CITY OF ALBUQUERQUE

October 12, 2021

Re: Chase Bank - ATM
2529 San Mateo NE
Traffic Circulation Layout
Architect's Stamp NONE provided (H17-D049)

ENLARGED DEMO SITE PLAN

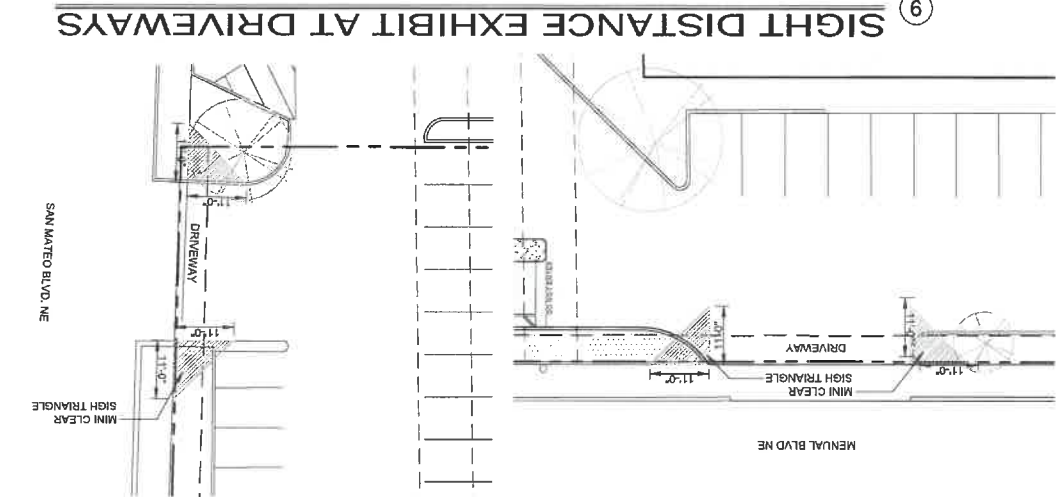
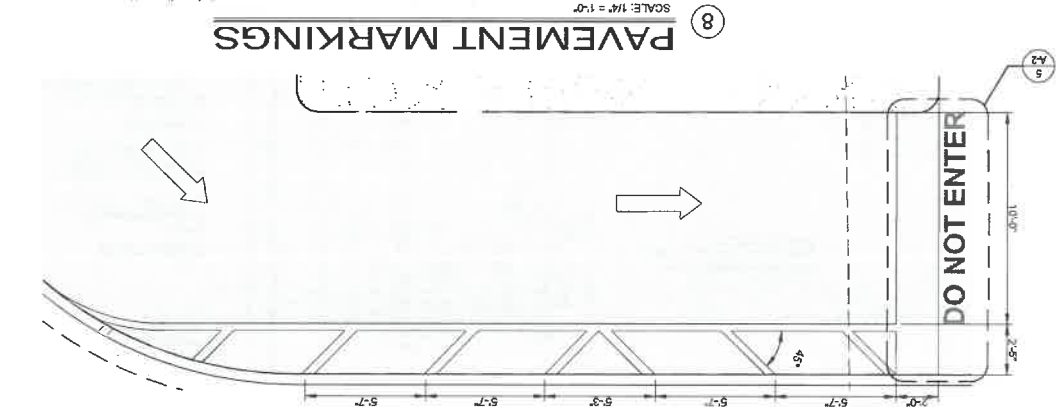
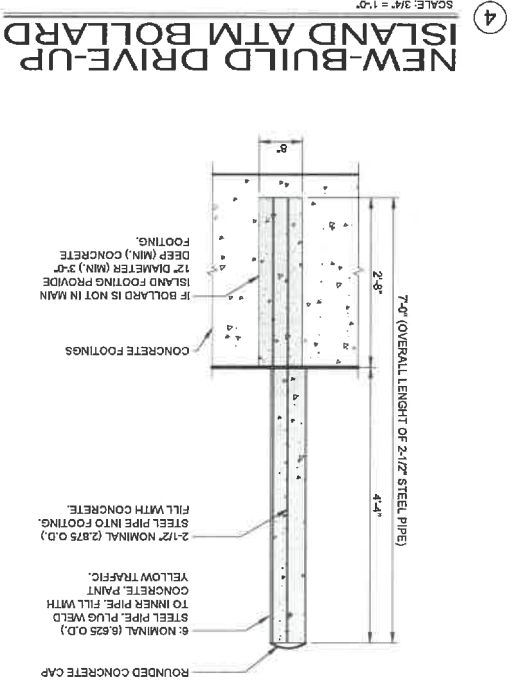
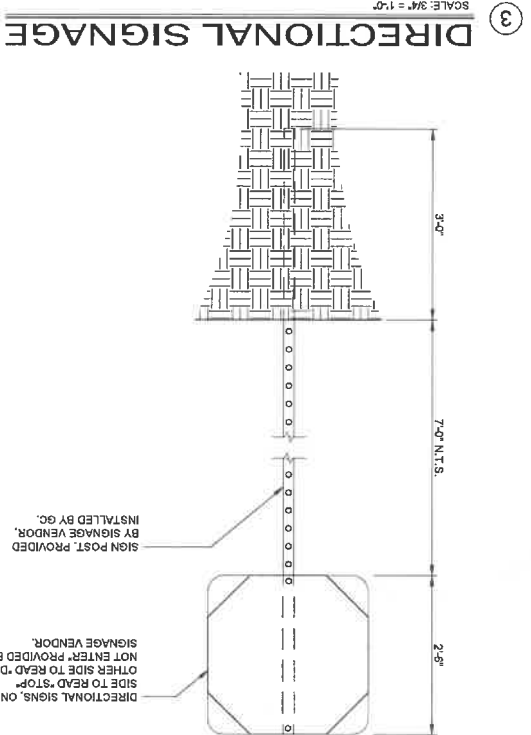
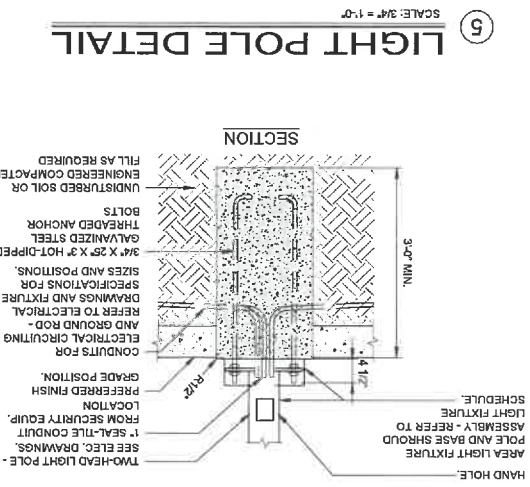
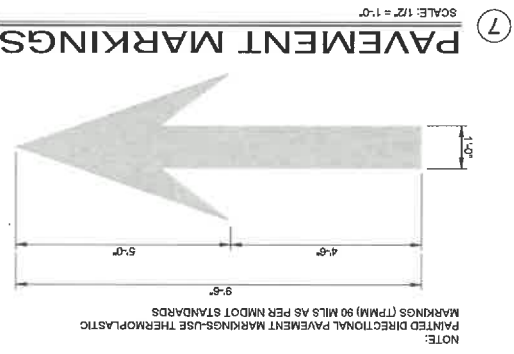
1. San Mateo driveway (adjacent to proposed ATM):

- Remove existing drivepad due to the proximity to Arterial intersections.
- If not remove, verify the drivepad is ADA accessible/compliant and if not replace driveway with current/update drivepad per COA standards.
